Hornsea Project Four

Applicant's Responses to the ExA's Second Written Questions

Deadline 5, Date: 20 June 2022

Document Reference: G5.2

**Drawing Name:**  
Information Plan

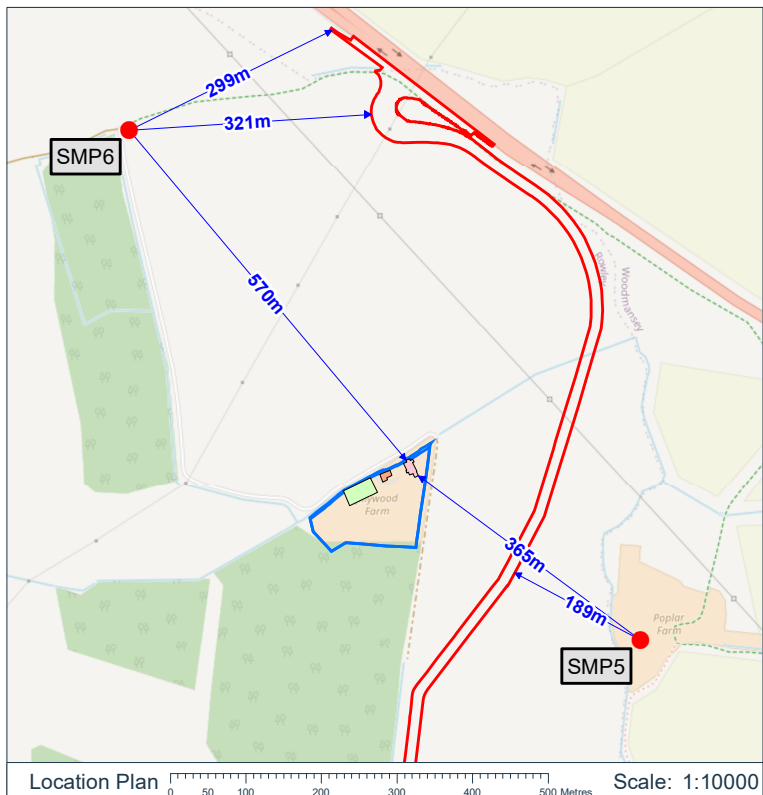
BGC.2.3	Applicant	<p>Jillywood Farm [RR-013], [REP2-074] and [REP4-061] raise concerns regarding the effects of the Proposed Development on Jillywood Farm. Whilst the Examining Authority (ExA) notes that you have responded to [RR-013] and [REP2-074], in order to facilitate Examination of this matter the ExA requests that these responses be drawn together along with a response to REP4-061 in one document. (You may wish to combine the answer to this question with your response to questions PDS.2.1 and TT.2.3)</p>	<p>The Applicant's submitted responses to RR-013 (response reference REP1-038), REP2-074 (response reference REP3-031) and REP4-061 (new response as Deadline 5) have been collated and are provided in Appendix A of this document.</p>
BGC.2.4	Applicant All parties entering into a Statement of Common Ground with the Applicant	<p>Statements of Common Ground</p> <p>A significant number of matters remain unresolved in the various Statement of Common Ground In each case, could the Applicant please indicate your expectations in terms of reaching a conclusion, or highlight any fundamental problems that you may be experiencing in progressing negotiations.</p> <p>Please note that should matters not be resolved in a SoCG, the ExA will require the submission of Final Position Statements from relevant parties by no later than Deadline 7.</p>	<p>Please see document G1.32 Applicant's Statement of Commonality of Statements of Common Ground submitted at Deadline 5 for an update on all current Statements of Common Ground.</p>
